**AeroSuperBatics  
Rendcomb Airfield  
White Way  
Cirencester  
Gloucestershire  
GL7 7DF**

*ADDITIONAL INFORMATION*

Acoustics Report 2122/R03  
2<sup>nd</sup> August 2023

Figure 7. Saturday 22/10/22 survey data

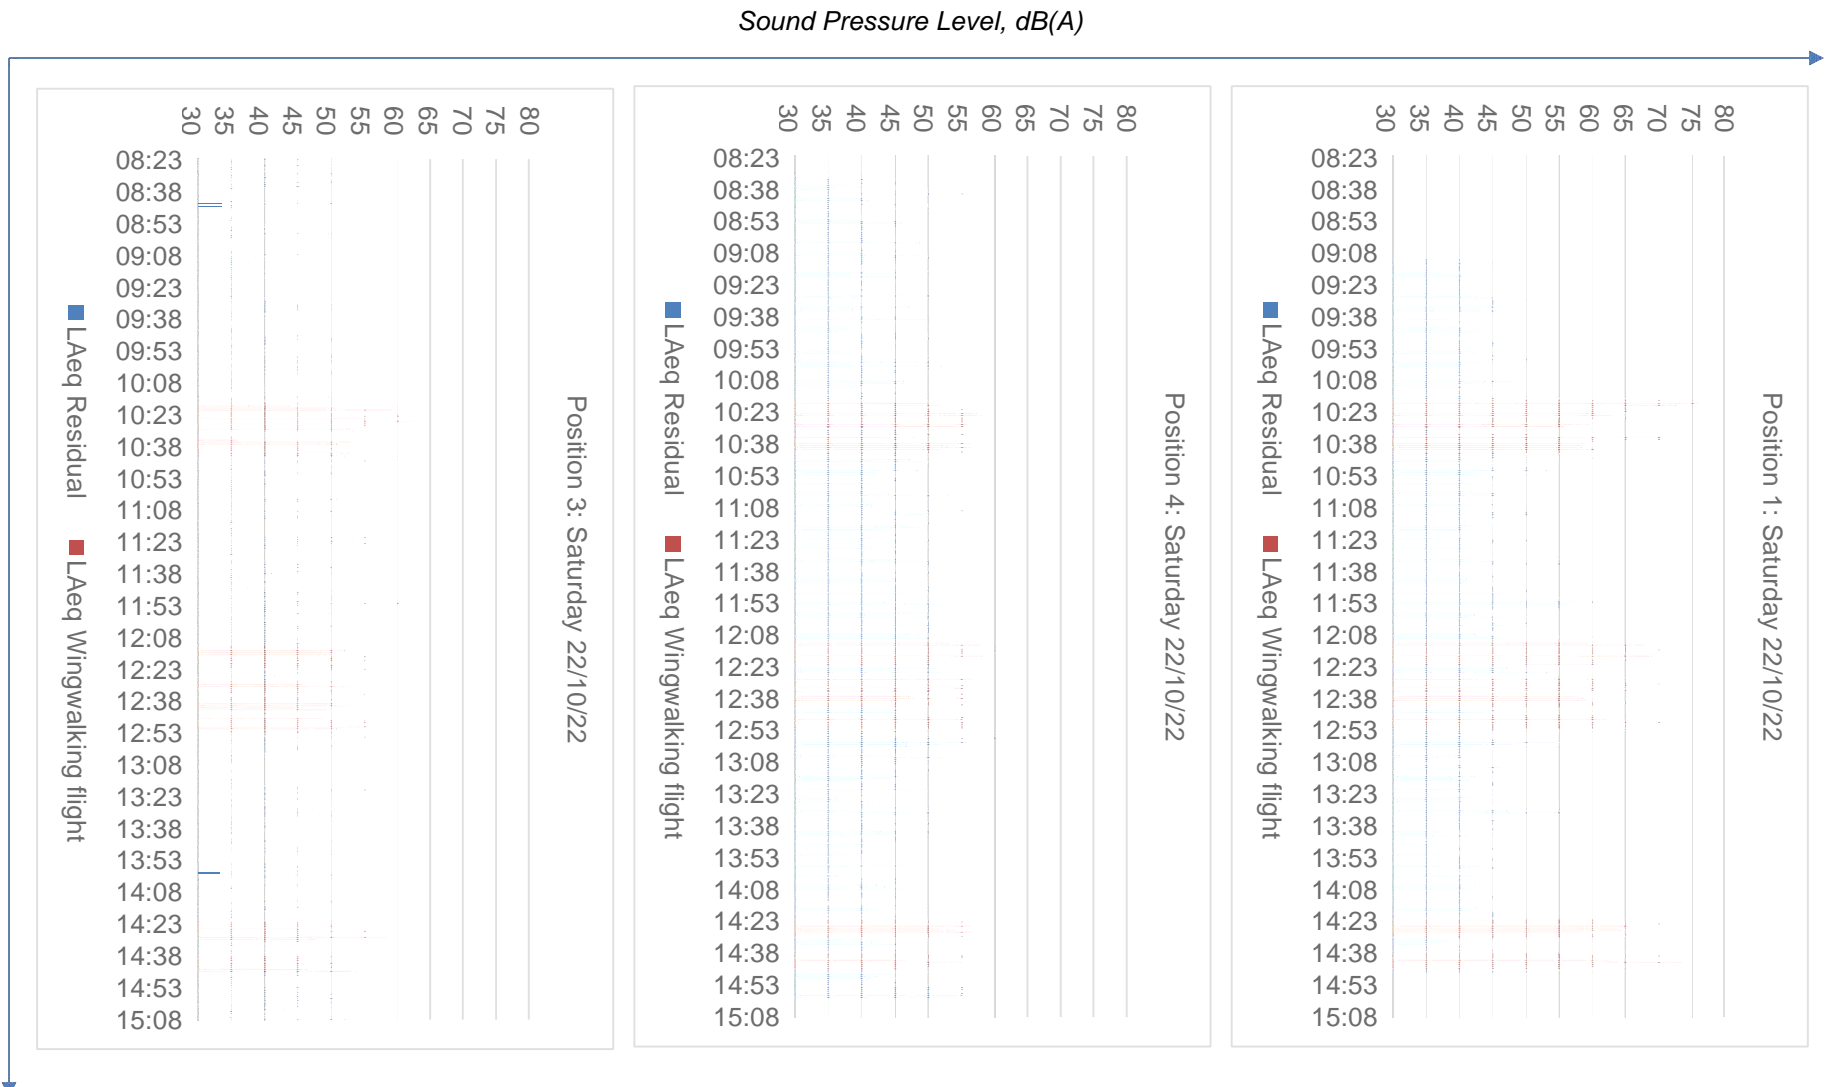
**SEC:** Clarification on how observation/analysis has been used to define periods with and without flight in the unattended graphs. From review of unattended graphs it would appear to show high noise levels which have not been attributed to wingwalking flanking the periods with wingwalking. Did Rendcomb Airfield provide engine on/off times or flight logs to define the flight times? And has consideration been given to remove potentially anomalous events?

**SEC:** Please kindly provide the tabulated 1-minute data used to produce the unattended graphs

**Matrix:** AeroSuperBatics provided the number of flights on each surveyed day, and additionally the approximate flight times on the 23 & 24/9/22.

During periods that the surveys were attended, the start and end times of the flights were recorded, which included taxiing and engine on times. For periods that the monitors were unattended, the survey data was analysed to identify sections of corresponding elevated noise levels at Positions 1, 3 and 4; the elevated values recorded at Position 1 informed on the total duration of the flight.

The number of identified flights (observed and determined from analysis of the noise data) matched the number of flights provided by AeroSuperBatics.

The noise levels recorded at Positions 1, 3 and 4 during the wingwalking flights will have also included the contribution of non-wingwalking noise sources; due to the irregular occurrence of these noise events it is not

possible to remove the contribution of these other noise events from the survey data.

The elevated noise levels recorded outside of the flight periods will have been due to various other noise sources such as passing vehicles or non-wingwalking over-flights.

**Matrix:** Tables 1 – 6 provide the consecutive 1-minute noise data obtained at measurement Positions 1, 3 and 4. The periods of identified wingwalking flights (either from observation or analysis of the noise data) are presented in red.
